App# 0650013886

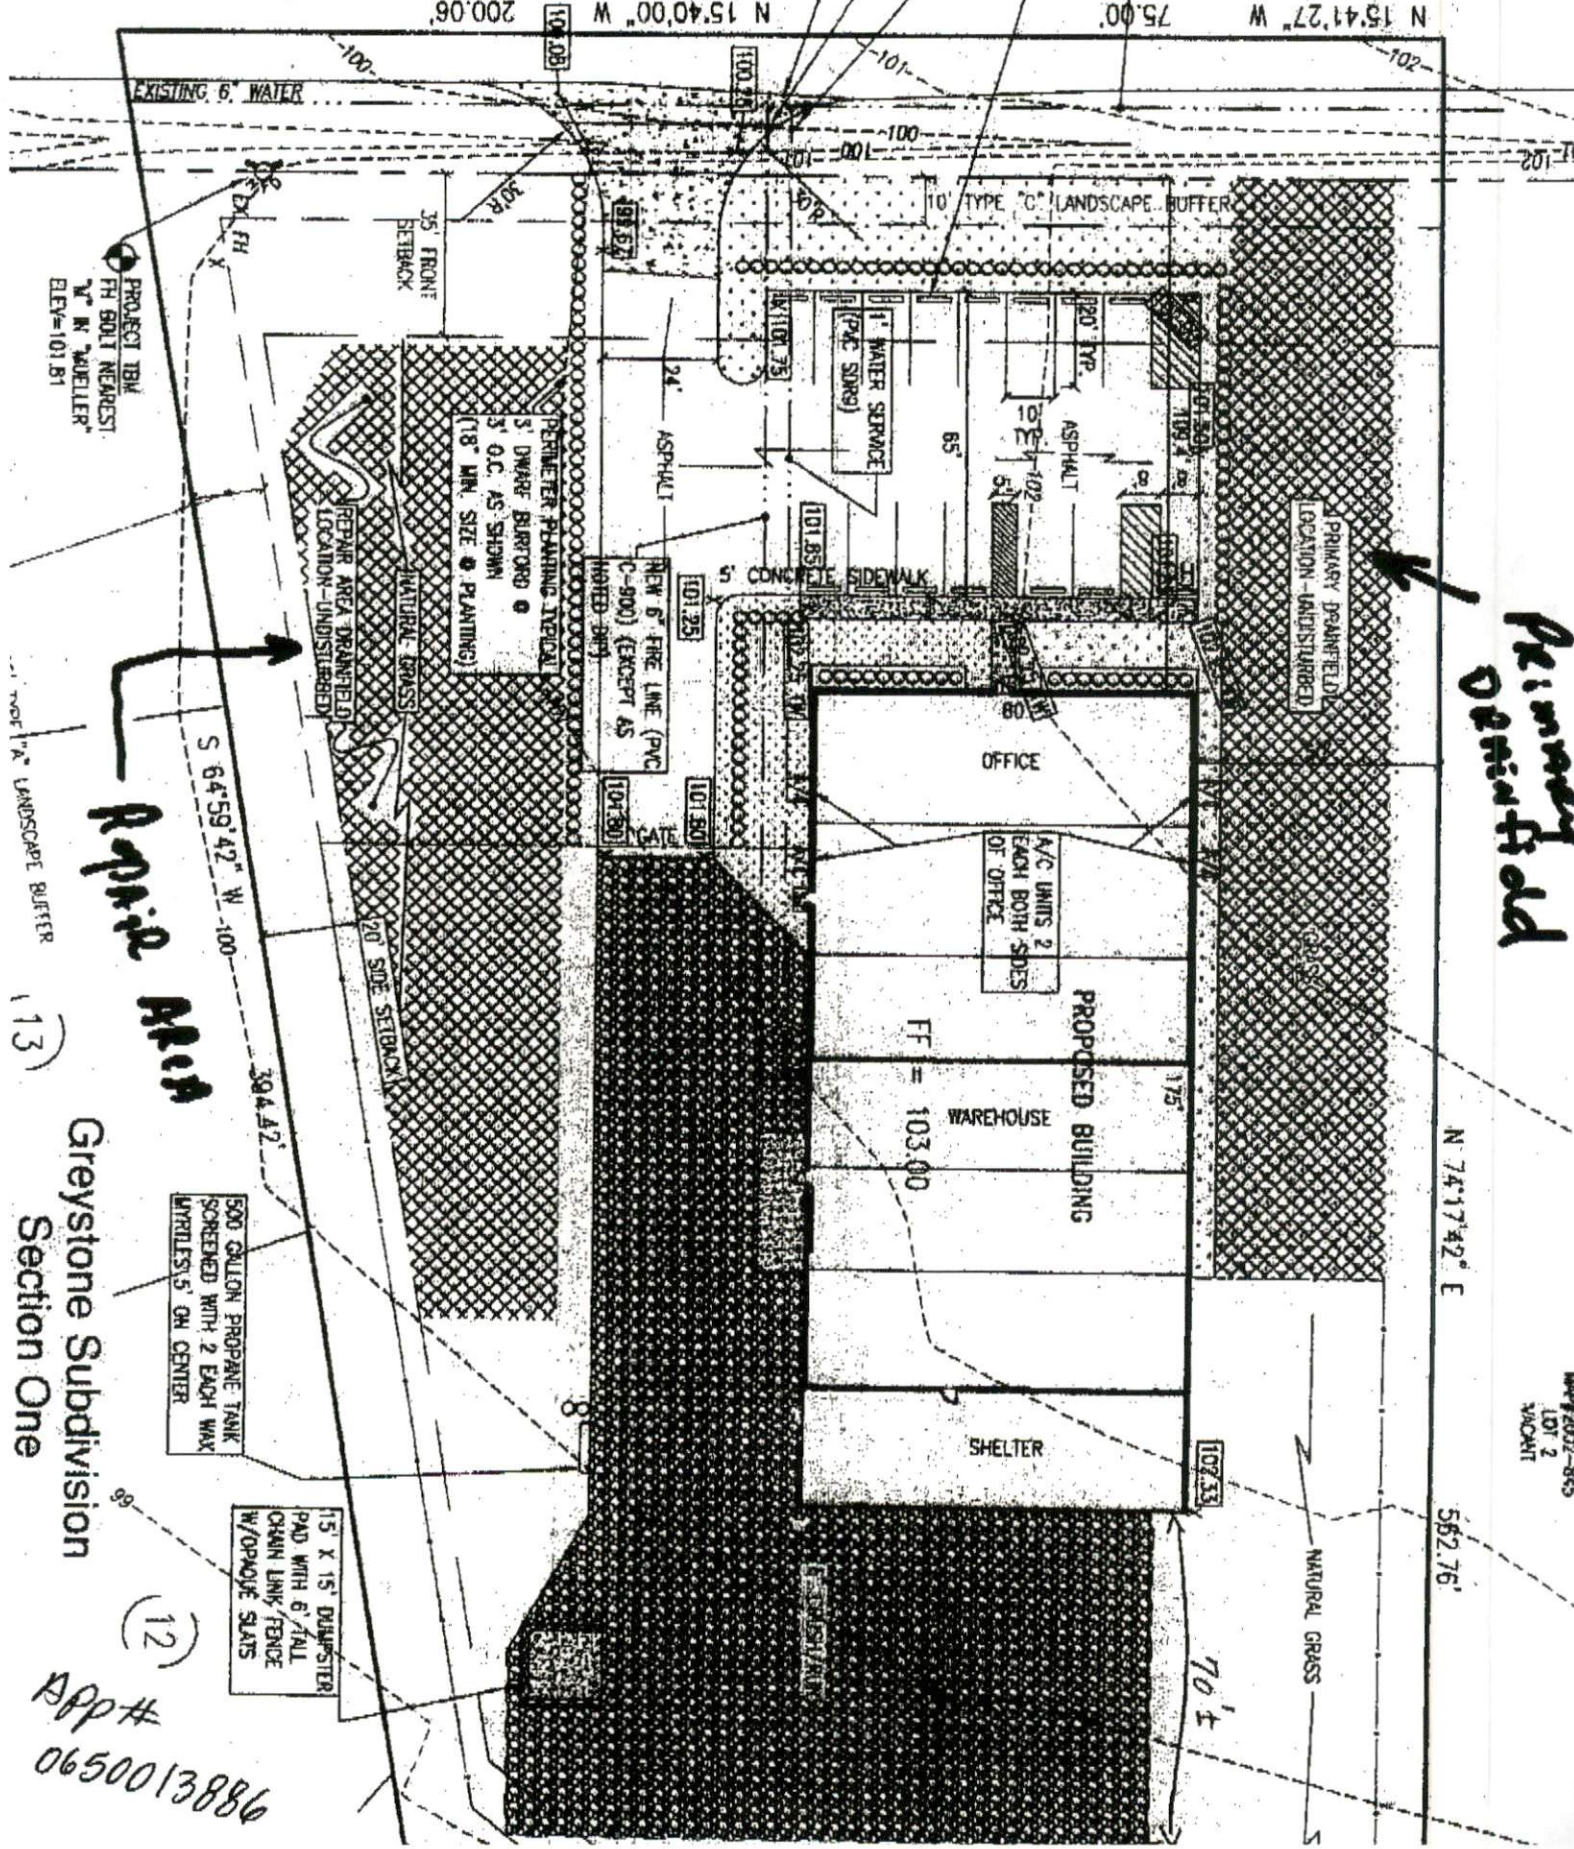
Show profile locations and other site features (dimensions, reference or benchmark, and North).

- * CHECK Preliminary
- * NEED more CLEAR MAP
- * Building size NOT by footage
